Your Ref: OWPC20737
Our Ref: FG/196/18/PL 26-10-2018
Please ask for:
Mrs A Gardner

Demolition of existing detached dwelling & detached garage & construction of 1 No. new detached dwelling.

12 West Drive Ferring

Proposed First Floor Plan
Scale 1:100

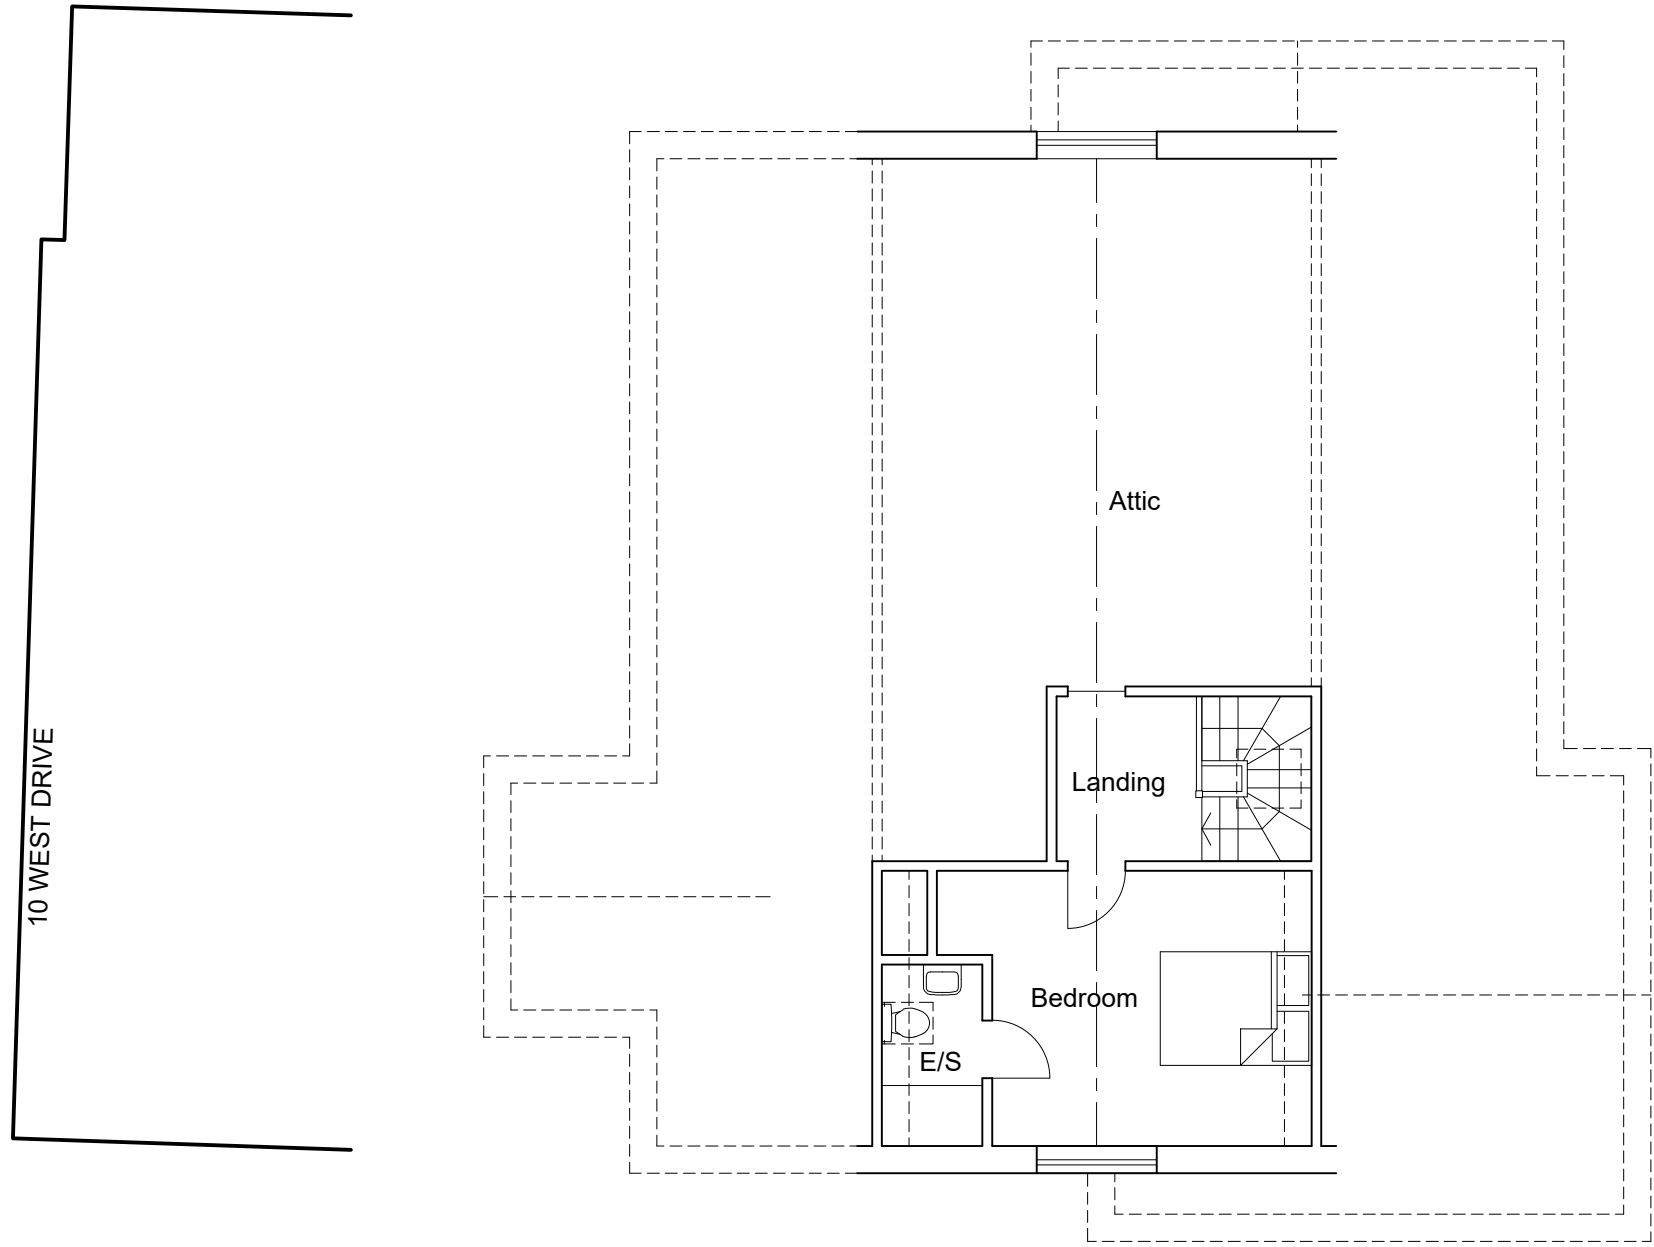
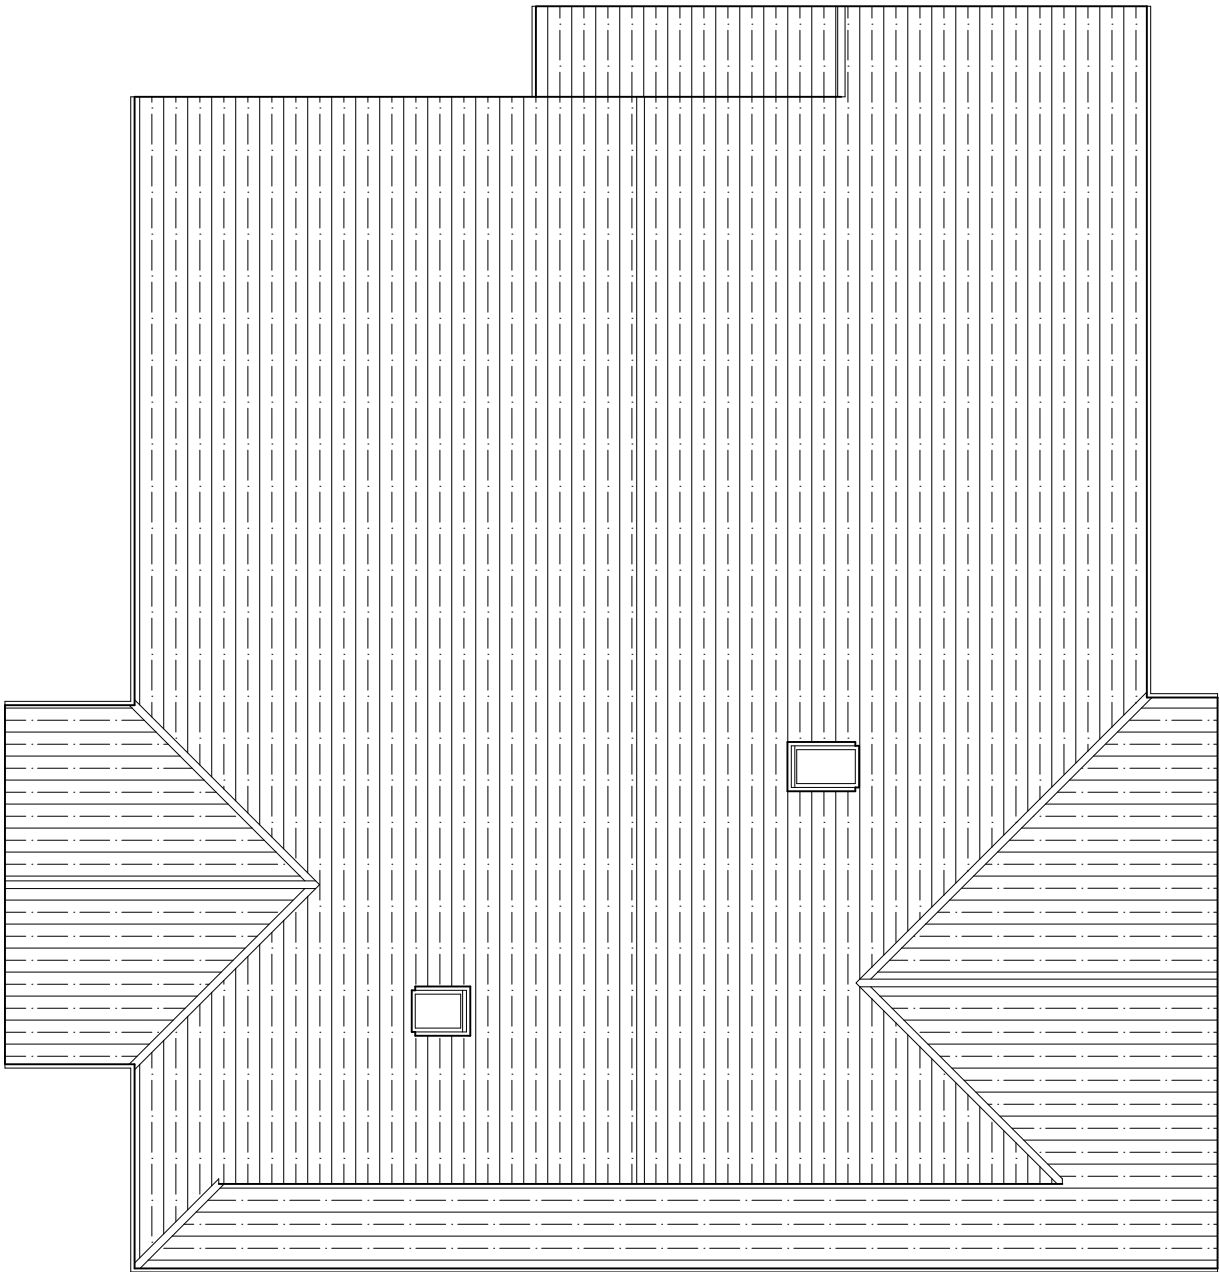
As can be seen from the plans there has been made obvious provisions for a large suite or bedroom on the first floor labled. attic . My objection is that screening trees that made my property secluded have already been felled so the window of the proposed " attic " will give an uninterrupted view into my house and garden, therefore the said window which an attic does not require must be removed to protect my privacy as it was for over 20 years prior to this proposed development
